APPLICATION NO.: M42Junction6
CASE OFFICER: Derek Lawlor
Tel: 0121 704 6434
dlawlor@solihull.gov.uk

TR010027 - Application by Highways England for an Order Granting Development Consent for the M42 Junction 6 Improvement

Matters to be responded to in accordance with Deadline 9 of Rule 6 letter dated 8th November 2019

**OPTION 1: INDICATIVE ALT. ARRANGEMENT TO REDUCE IMPACT ON CHURCH FARM LAND**

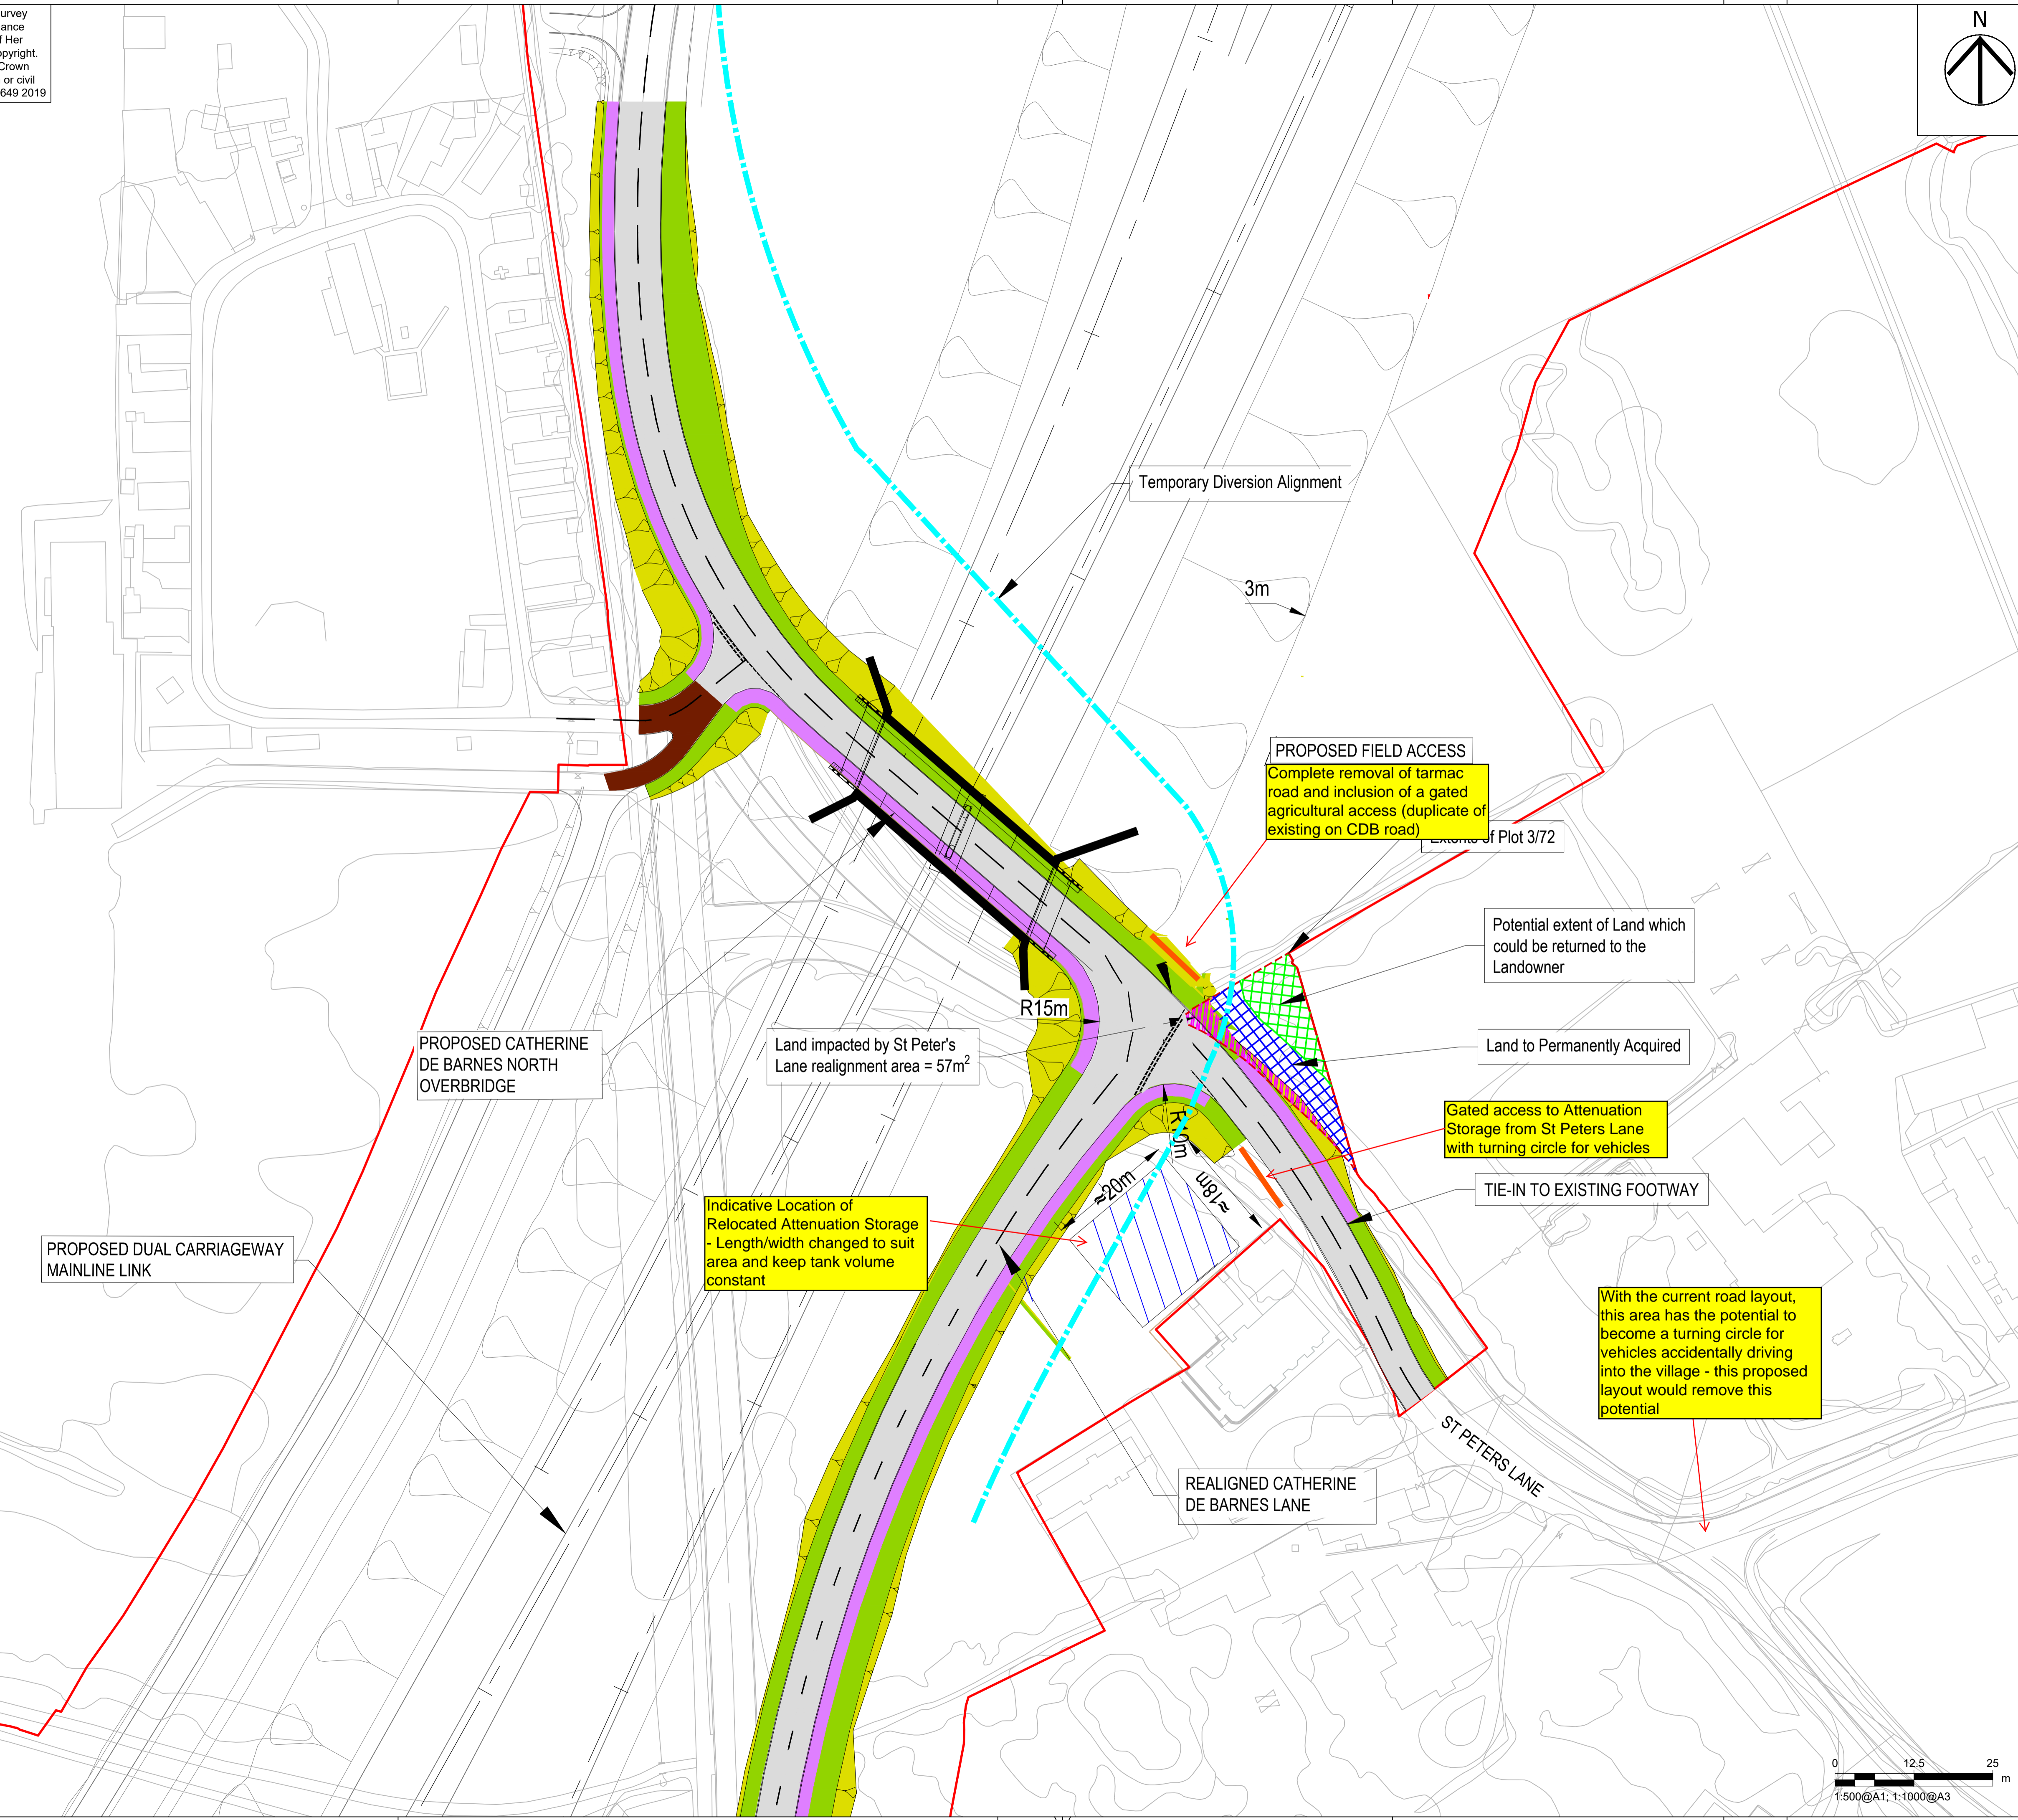
SMBC would not support a change in priority at this junction

SMBC and HE explored 3 design options for the priority at re-aligned Catherine de Barnes Ln/ St Peters Ln junction depending on the available land and taking into consideration the number and severity of the departures from standard that associated with each design option;

Option 1; the priority is for traffic on the re-aligned Catherin de Barnes Lane heading toward St Peters Ln, due to the limited available land for this design layout, this option introduced a sharp bend on Catherine de Barnes Ln and limited forward visibility. This combination of a substandard layout and short of visibility would create a black spot of accident on this junction. In total there would be 11 departures from standard on this option.

Option 2, Due to the existence of street features including safety barriers and the limited available land, this option introduced sharp bend on Catherine de Barnes Ln and a short stopping sight distance around the corner. This combination of departures would create a high risk of accidents especially for traffic turning right on St Peters Ln. In total there are 8 departures from standard on this option

Option 3; priority for traffic on St Peters Ln to Catherine de Barnes Ln North overbridge – the preferred option

Option 3 has a priority for traffic on St Peters Ln heading toward

<p>Catherine de Barnes Ln North overbridge, with this layout, traffic on the re-aligned Catherine de Barnes Ln has to give way/stop for the traffic on the St Peters Ln. Therefore the sharp bend would have no effect on the traffic manoeuvres around the junction, also traffic intending to turn right onto/out of re-aligned Catherine de Barnes Ln would have good forward visibility, therefore the potential risk of accident on this layout have been reduced to the minimum. In total there are 5 departures from standard on this option</p> <p>SMBC therefore support Option 3</p>
14		<p>It is agreed that the relocation of the underground storage tank and its access on land to the south of St Peters Lane would not affect the drainage arrangements and that it would be within the Limits of Deviation for Work No.35 [REP6-015]. However, this option is discounted because the access and egress would require a departure from standard and those defects (the provision of a layby off the realigned Catherine-de-Barnes Lane) are deemed to entail an increased risk of fly tipping and unregulated taxi parking. The ExA consider that those impediments could be avoided with measures within the dDCO. Moreover, this option has the advantage of locating the drainage arrangements to a roadside rather than introducing them to an otherwise relatively secluded area; the access to the fields and the aqueduct on the northern side of St Peters Lane need thus only be to an agricultural standard. Hence, the ExA propose the insertion of a new R16 as follows: 16(1) Notwithstanding the details shown on any Certified Plan listed in</p>	<p>We have not been able in the short time to be able to obtain a response from our expert Officers but we could provide more feedback within 2 weeks if this was helpful</p>
